BE/104/14/NMA
cover letter

North Bersted – BRNRR – soft landscaping

We are pleased to enclose an application for non-material amendments to amend the soft landscaping scheme for the BRNRR which comprises the following material:

Drawing Number: **2115-PP-05** Revision: E

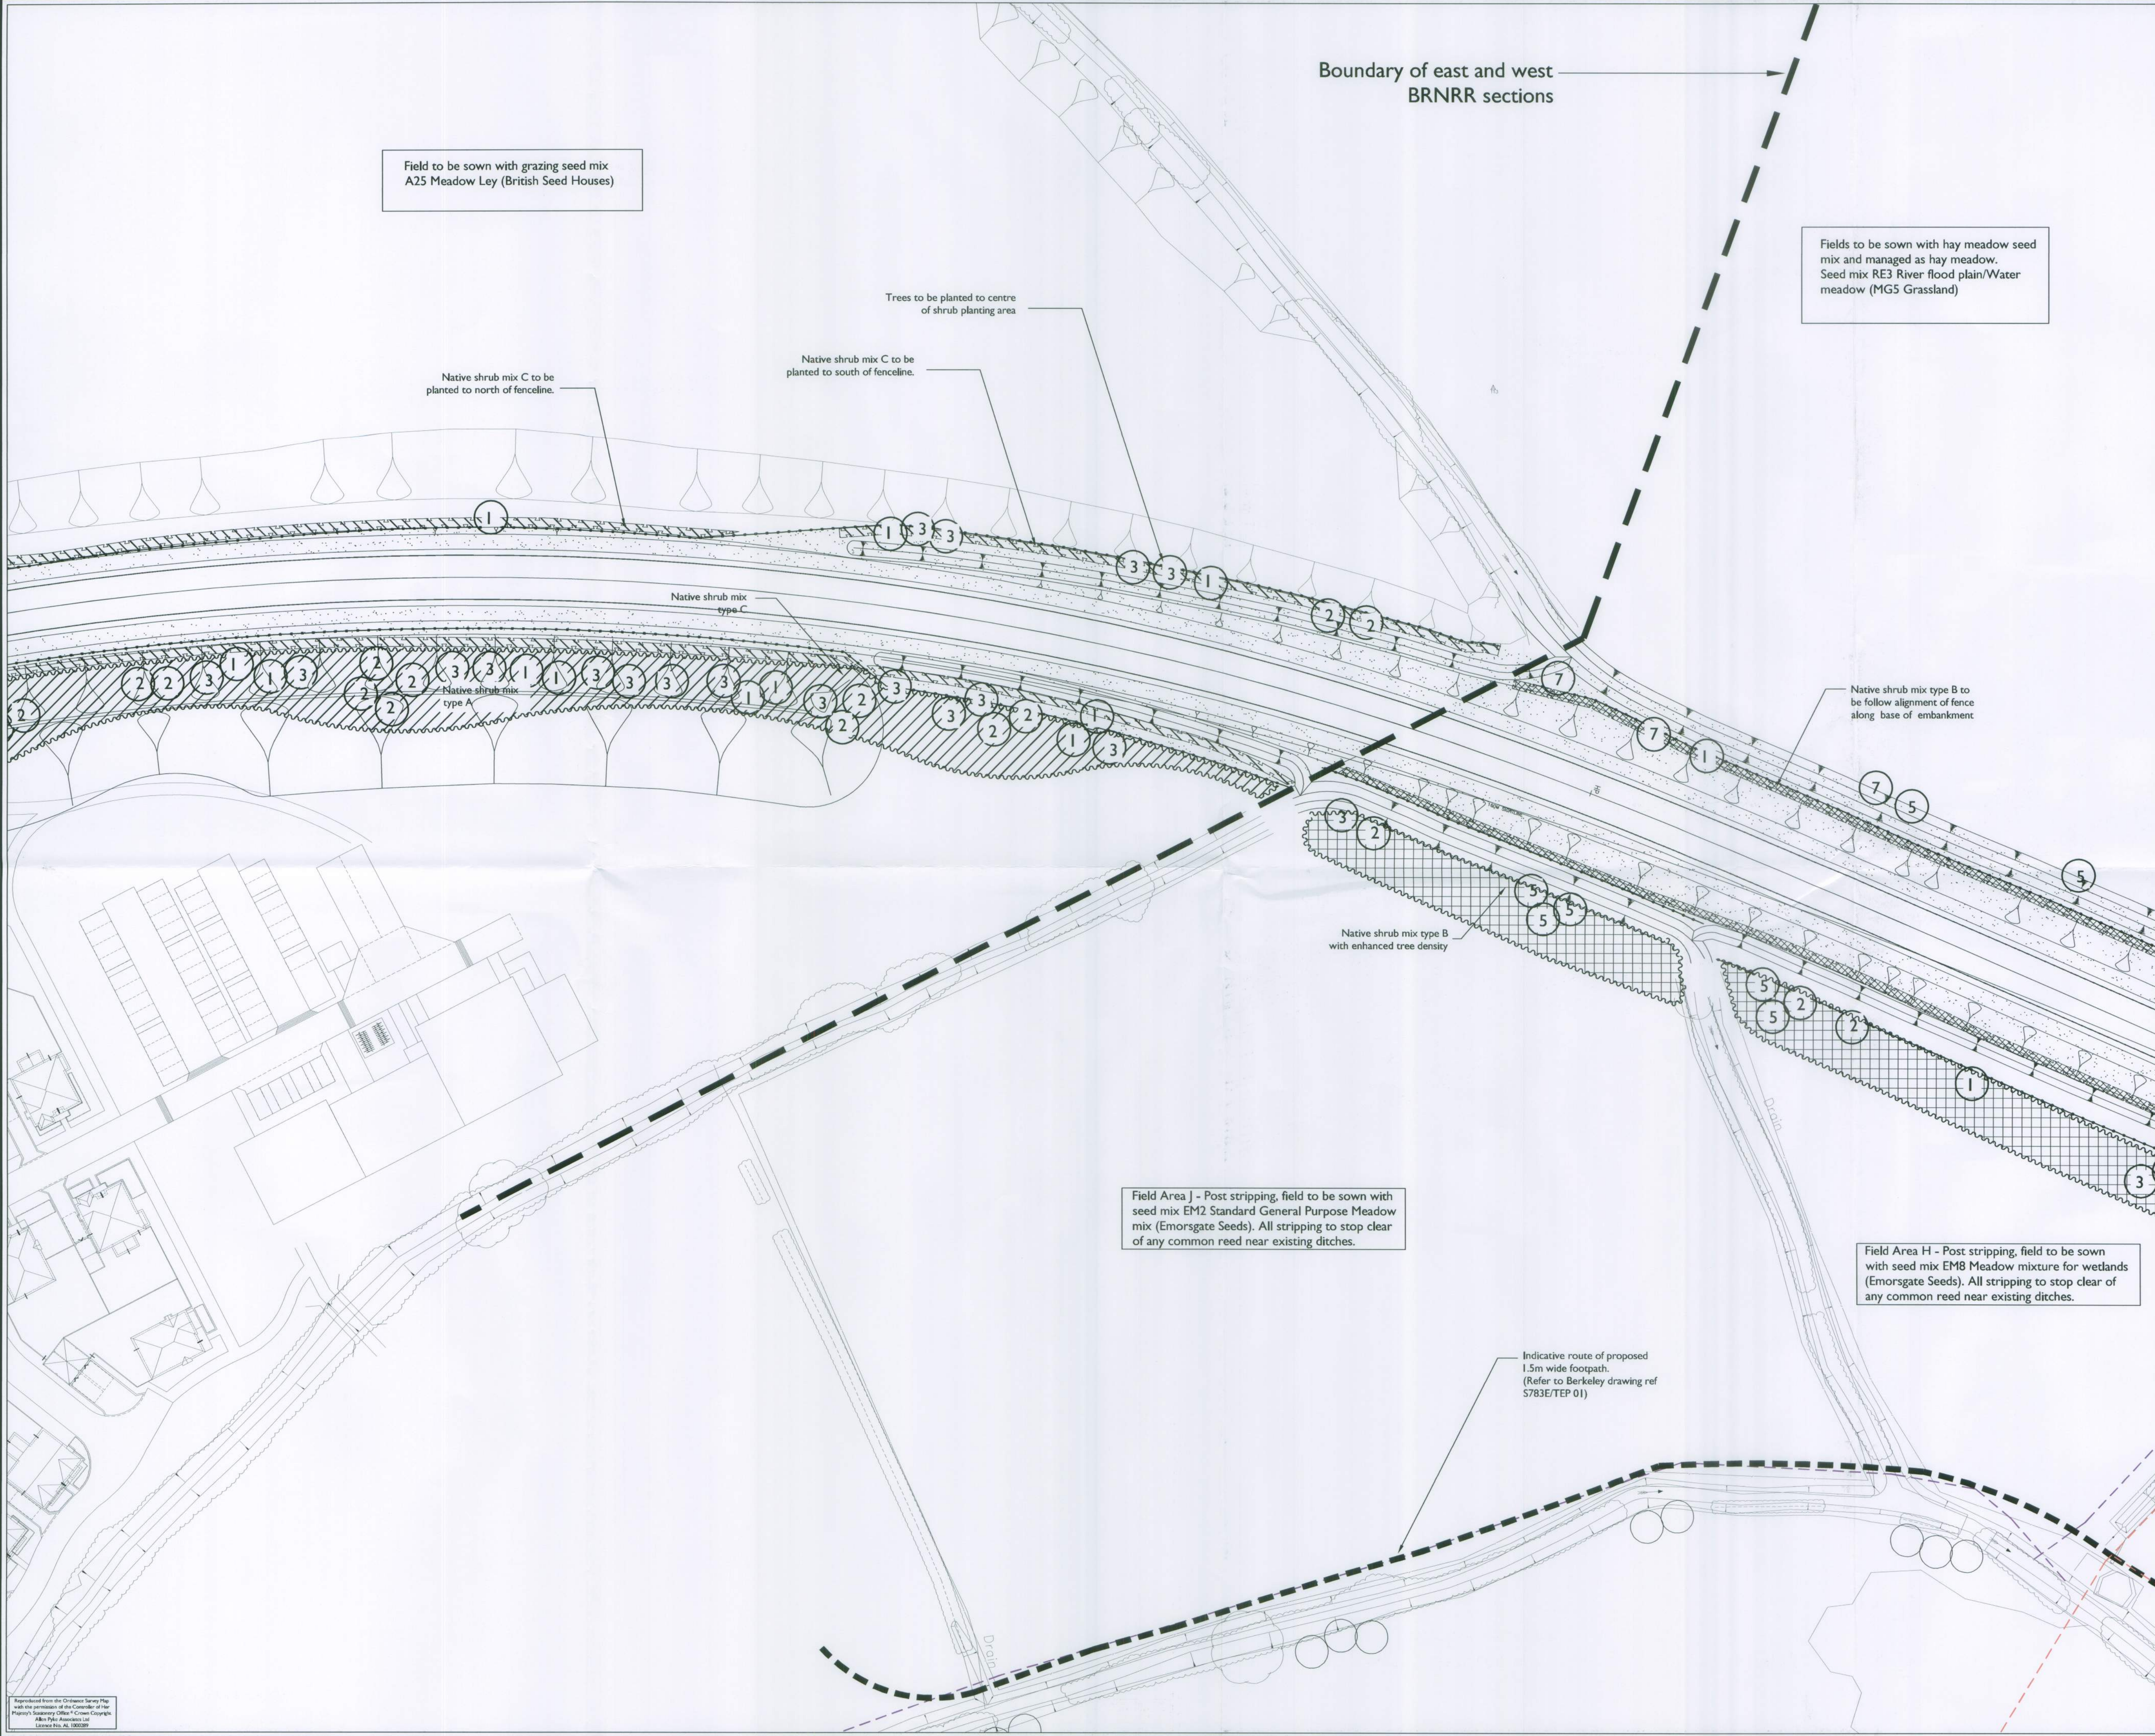
- Trees at the bottom of the noise bund to the south of the road will likely obstruct the visibility splay once matured – these have been located away from fence higher up noise bund
- There is a hedge / vision splay clash to the south of the road, planting therefore pulled slightly to the south
- Hedge and planting moved out of ditches.
- Trees moved out of embankment and ditches.
- Native shrub mix B which contains hawthorn, willow, poplar moved from the top of the embankment to the bottom of the embankment side slopes, between the toe and the fence. This also removes the conflict with the siting of a large drain adjacent to the road.
- Native shrub mix type B with enhanced tree density moved from the south embankment into the adjacent fields
- Field H & J seed details added

Drawing Number
2115-PP-06

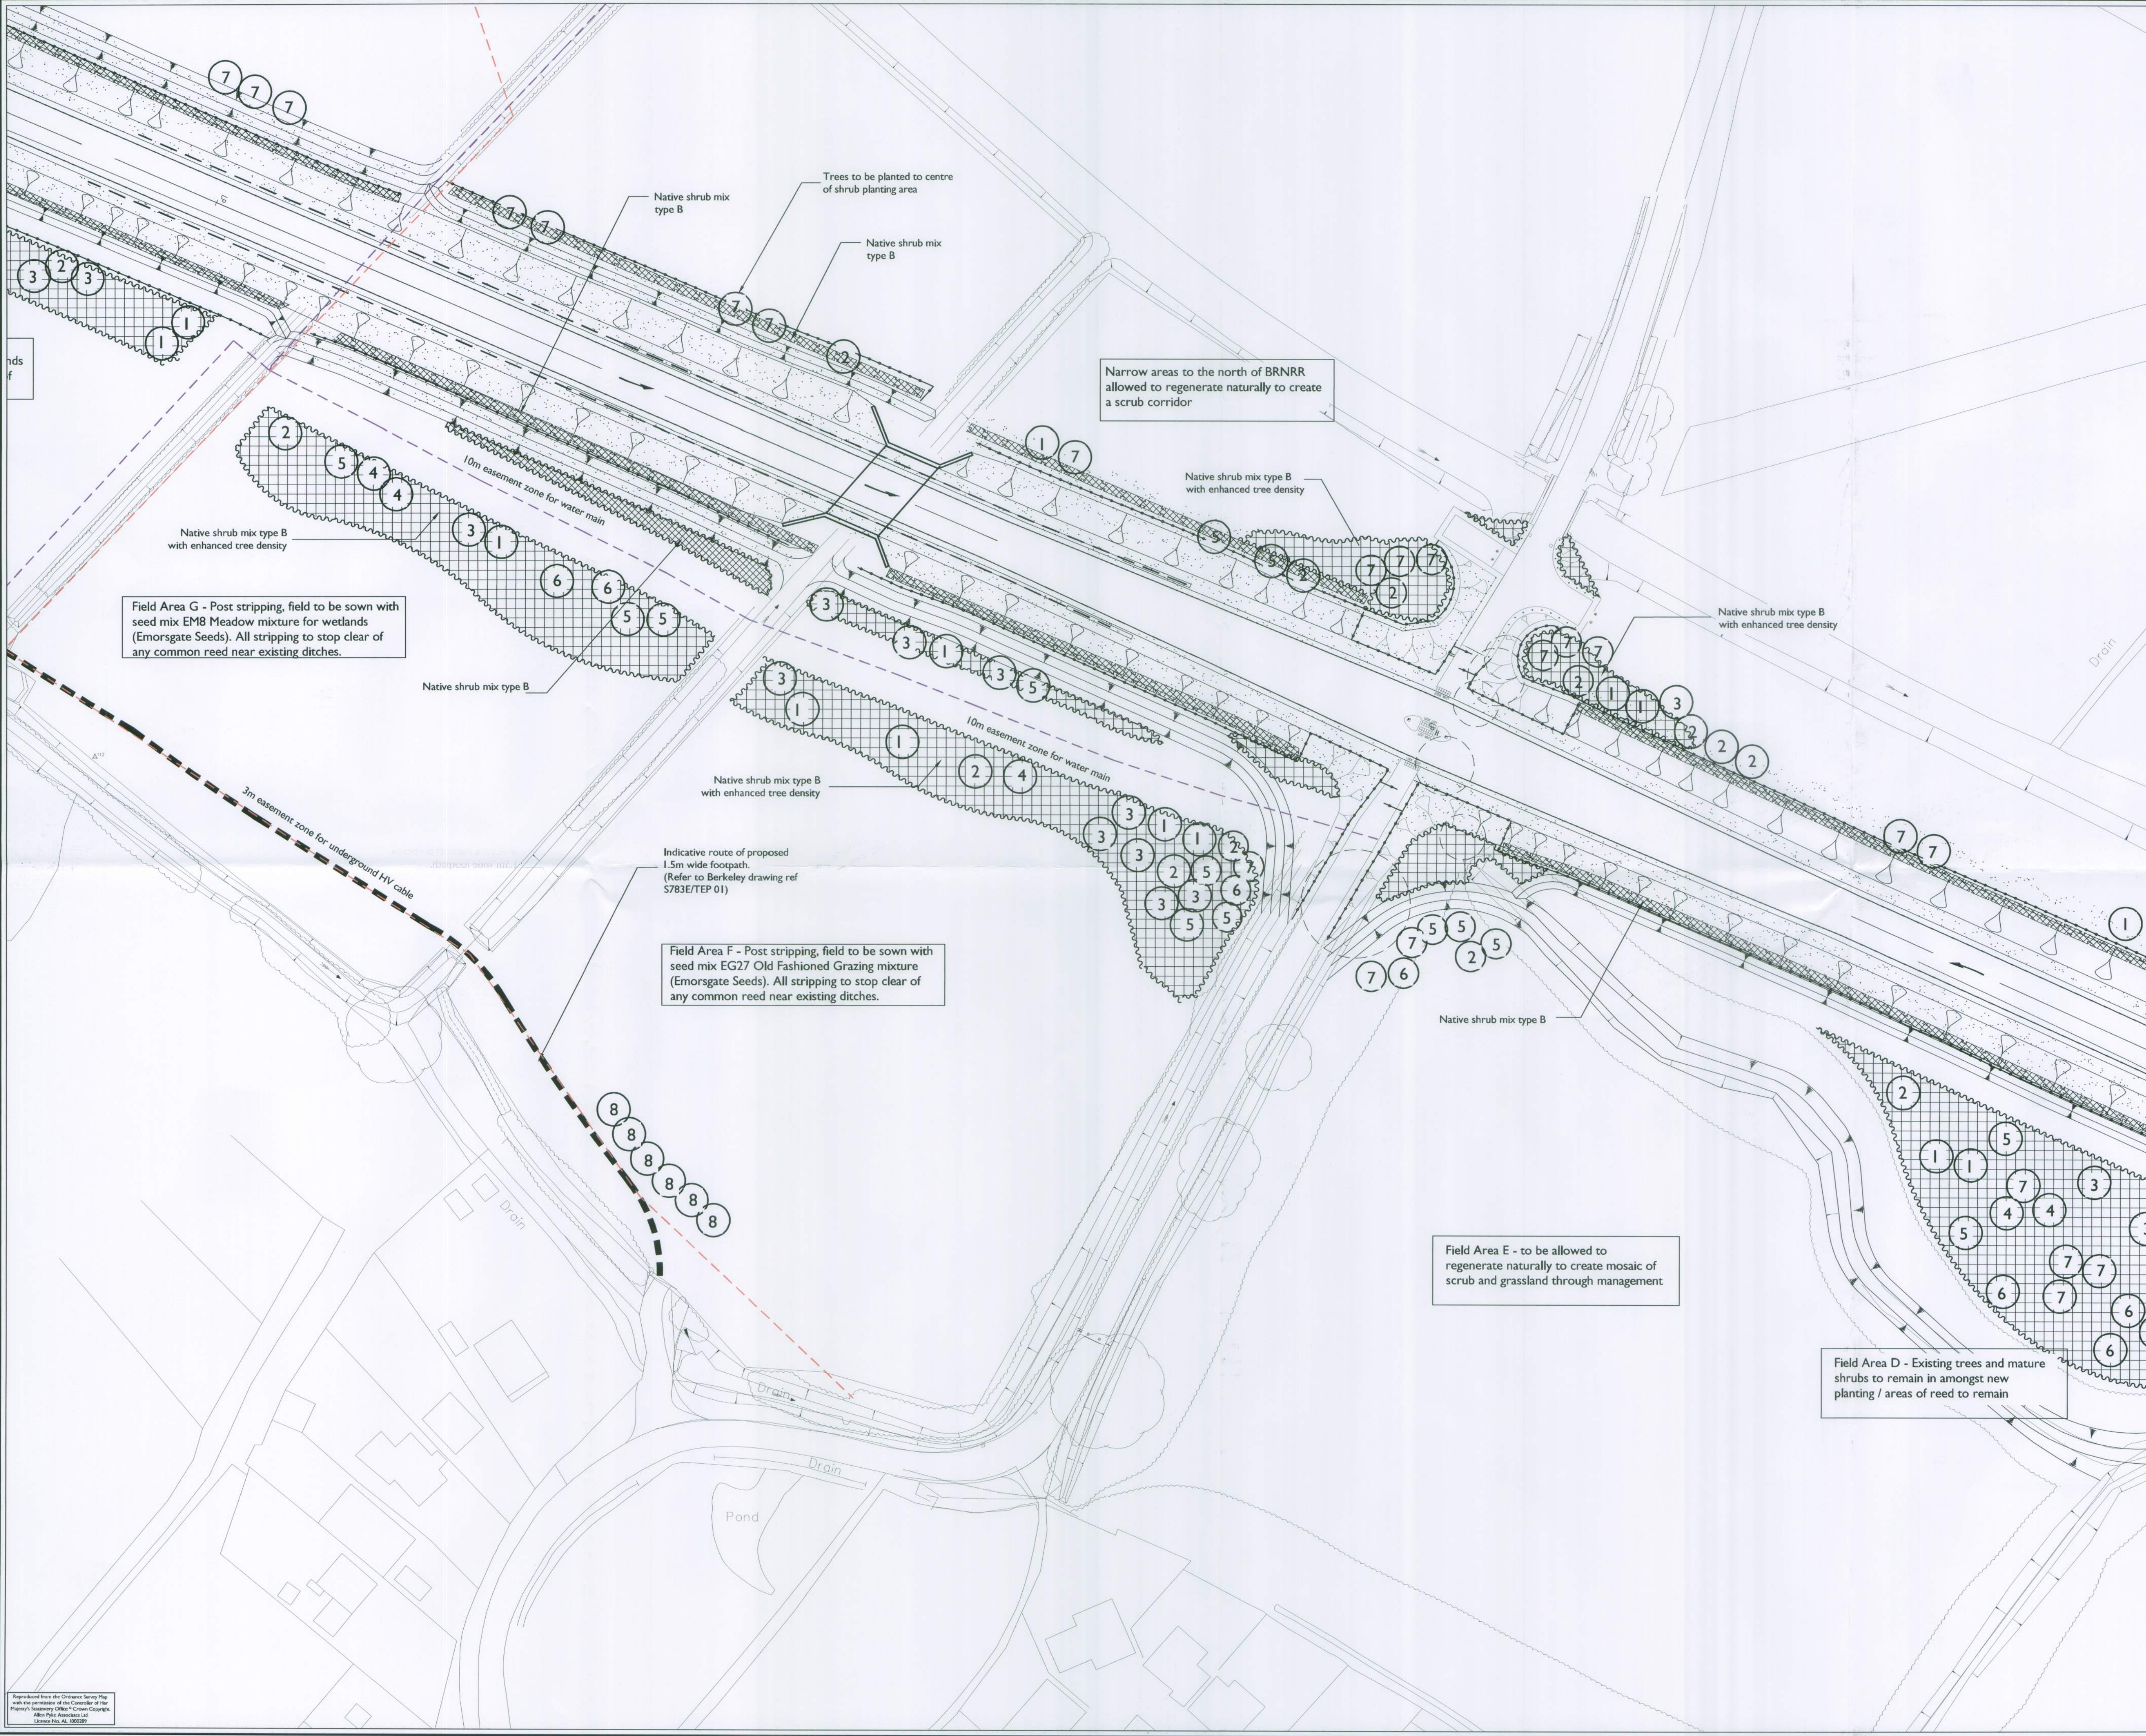
- Field F & G seed details added
- Route of HV electric shown for CDM purposes. Trees and shrubs located at least 1.5m away either side
- Route of water main added to ensure tree and shrubs are located at least 5m away either side
- Hedge and planting moved out of ditches.
- Trees moved out of embankment and ditches, which also removes conflict with proposed street lights
- Hedge moved from the top of the embankment and located at the bottom near the toe / fence
- Native shrub mix type B with enhanced tree density moved off the south embankment and into the adjacent fields
